re: Response to Engineering Comments
Proposed Residential Development
2710 Draper Avenue - Ottawa

date: March 21, 2019

file: PG1630-MEMO.17

Further to your request and authorization, Paterson Group (Paterson) prepared the following memorandum to respond to the current City of Ottawa engineering review comments for the aforementioned site. This memorandum should be read in conjunction with our geotechnical Report PG1630-4 Revision 1 dated February 21, 2019.

Drawing file: plan / All_Image Referencing_Site Plan Application_Image Reference_2019-04-11 - Stone Strong Retaining Wall - D07-12-18-0184.PDF

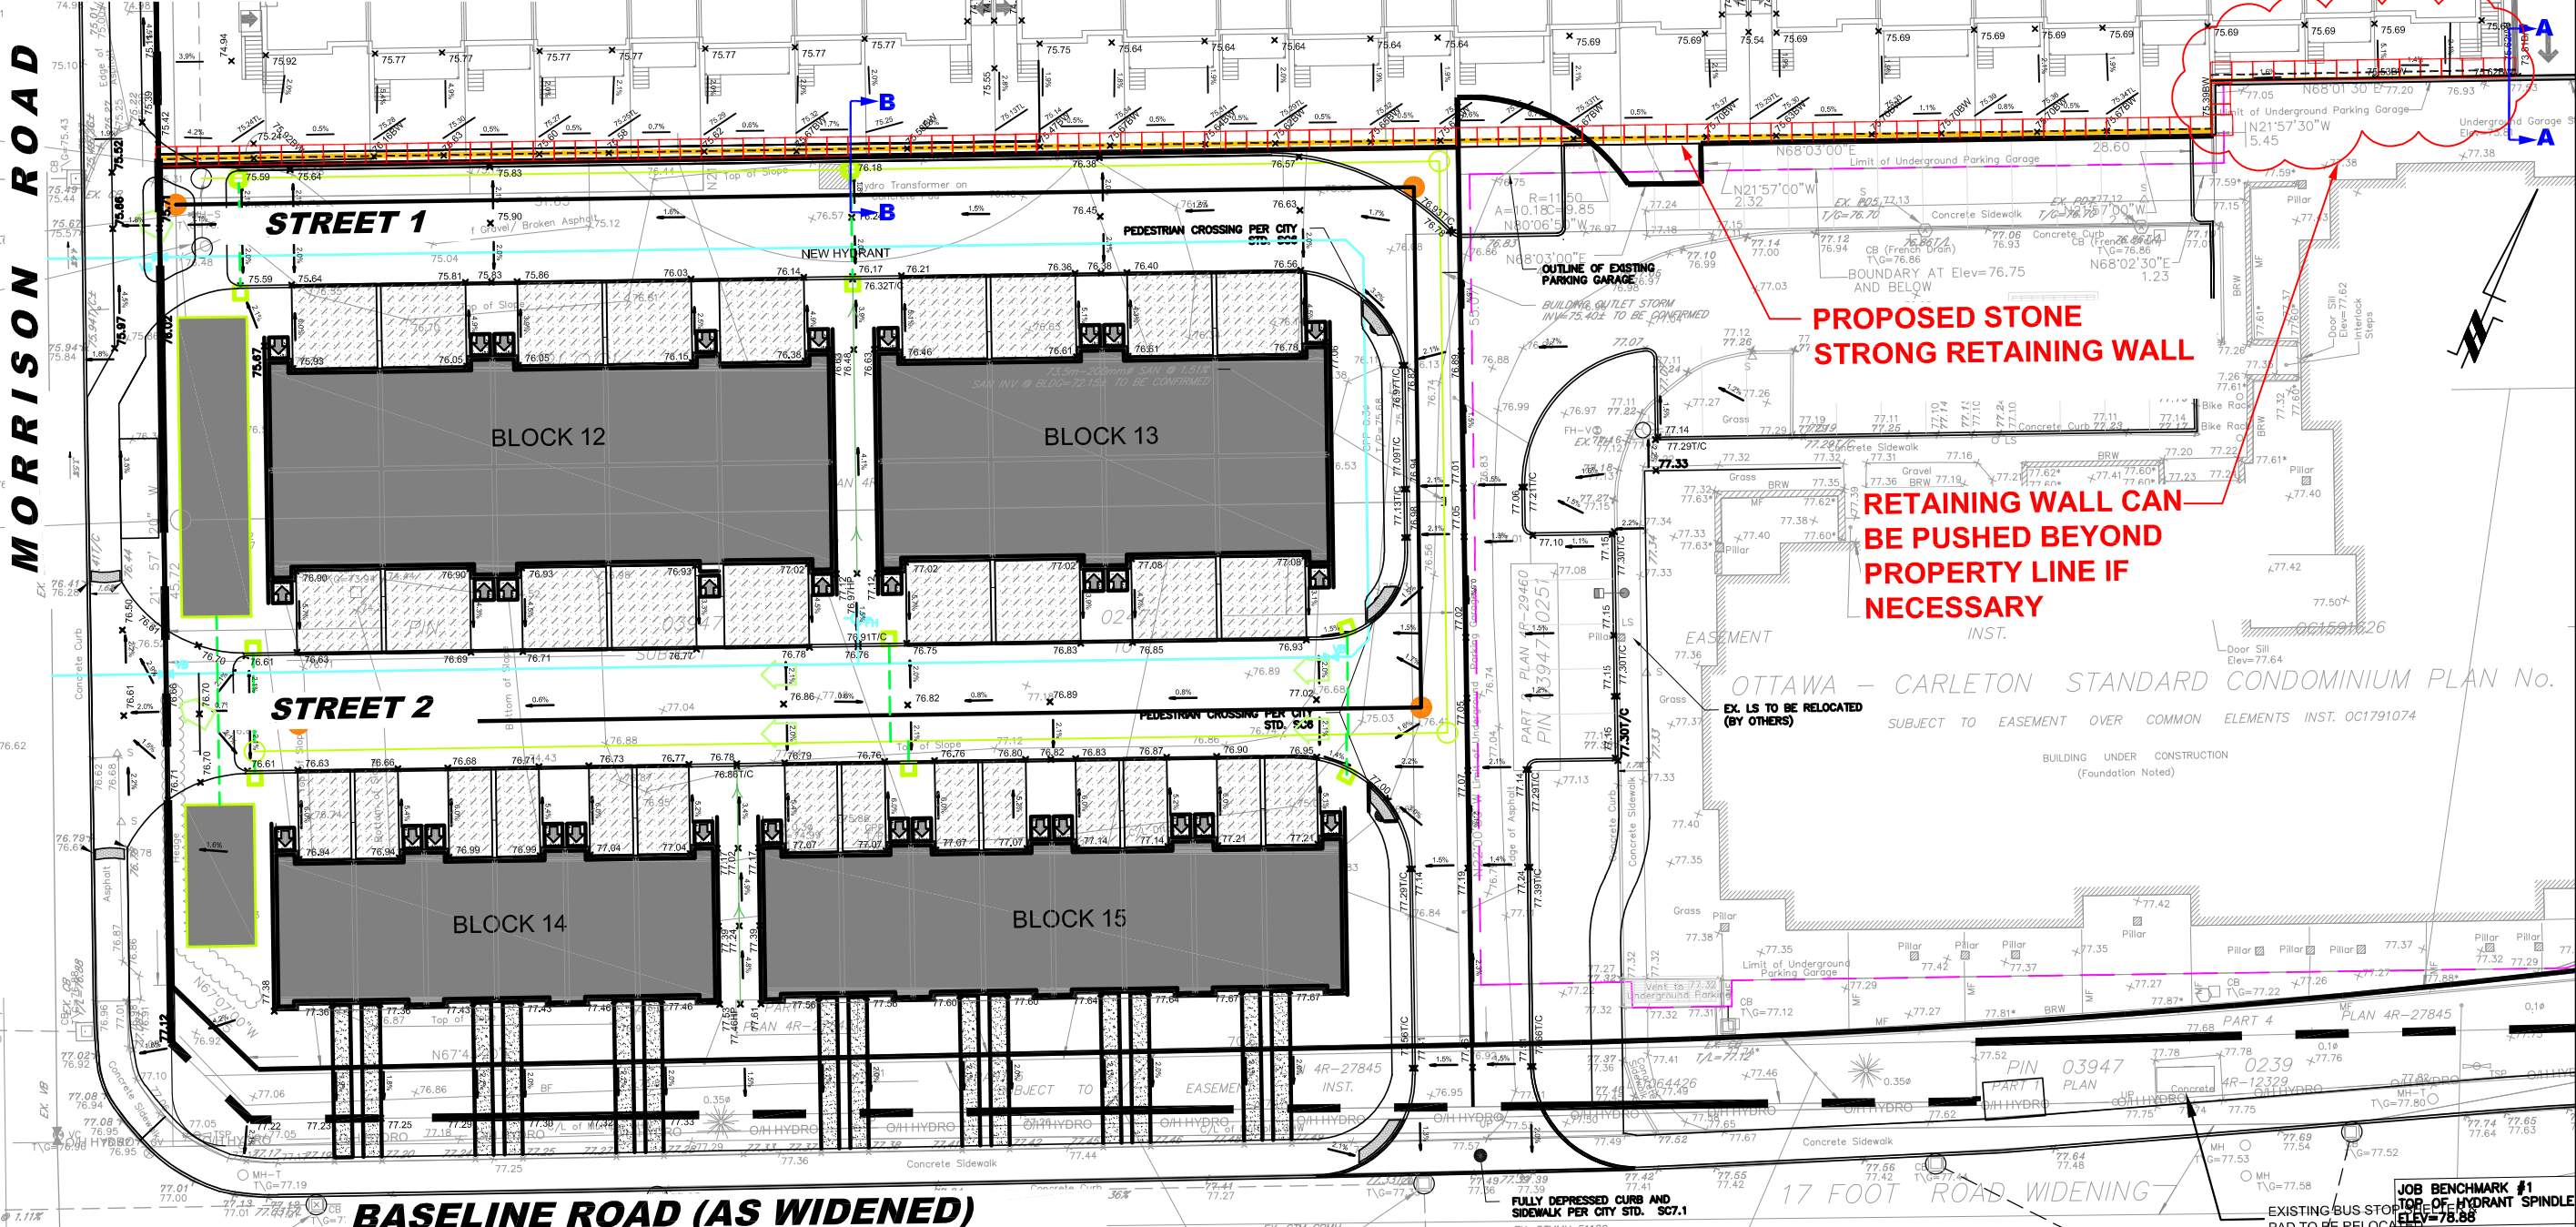
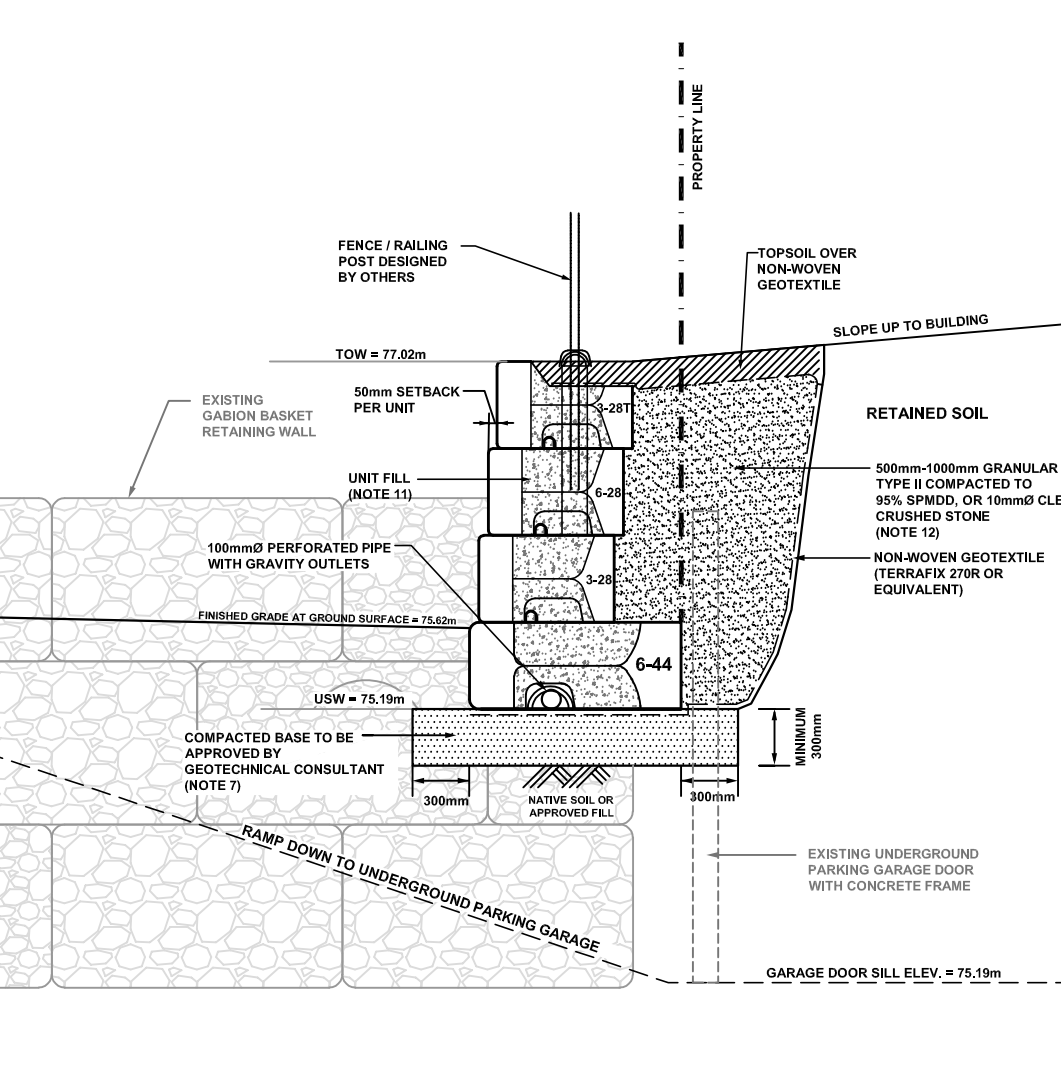
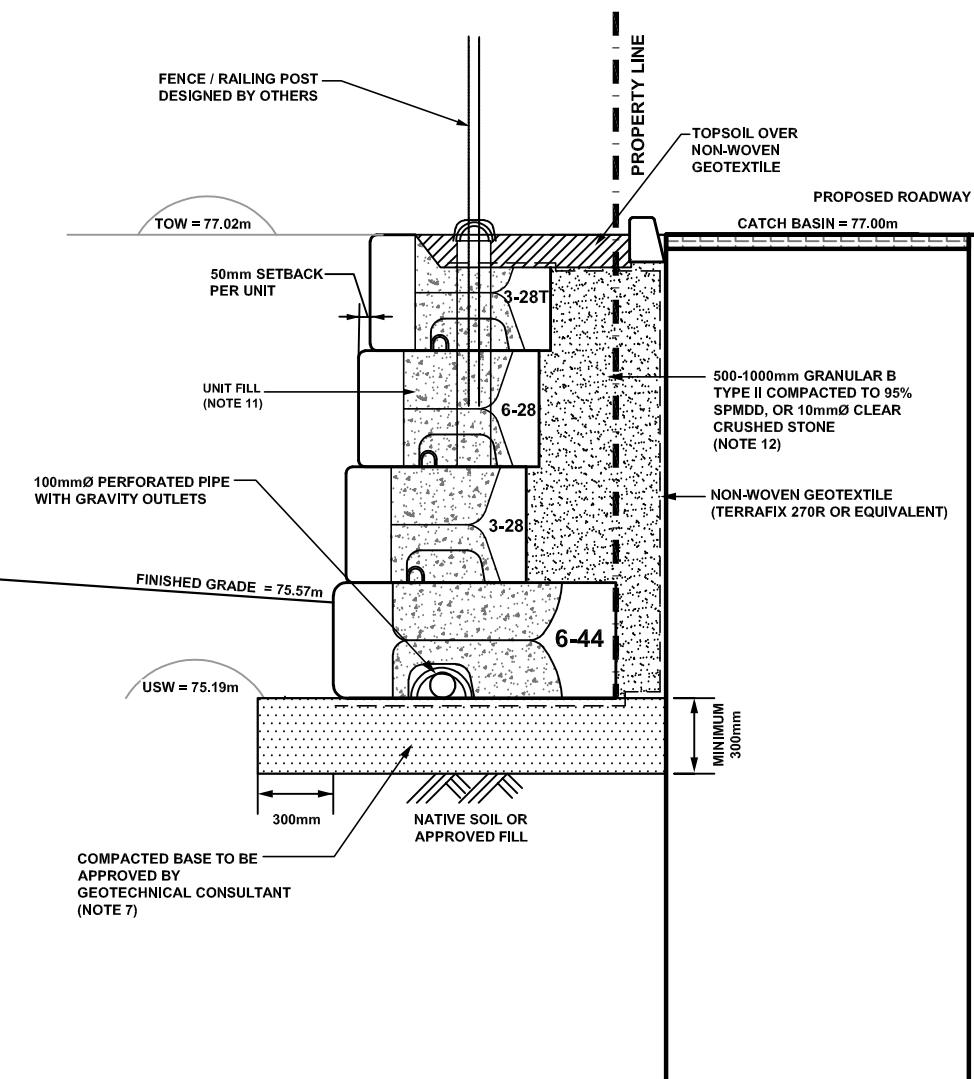
Comment: *A Retaining Wall Stability Analysis Report and Retaining Wall Structural Details are required to be provided that demonstrates that the proposed retaining wall (max height 1.61 m) along the south property line has been assessed for global instability. The cross-sectional structural detail plan to be provided is to be included as part of the civil engineering drawing set as a full size drawing. No retaining wall features shall encroach onto the adjacent lands.*

Comment: *A fence is required along the top of the retaining wall. Proposed fence details shall be shown on the plan to be provided.*

Response: Refer to Drawing PG1630-4 - Stone Strong Retaining Wall Design, attached.

Response: Proposed fence details will be shown on the retaining wall design drawing.
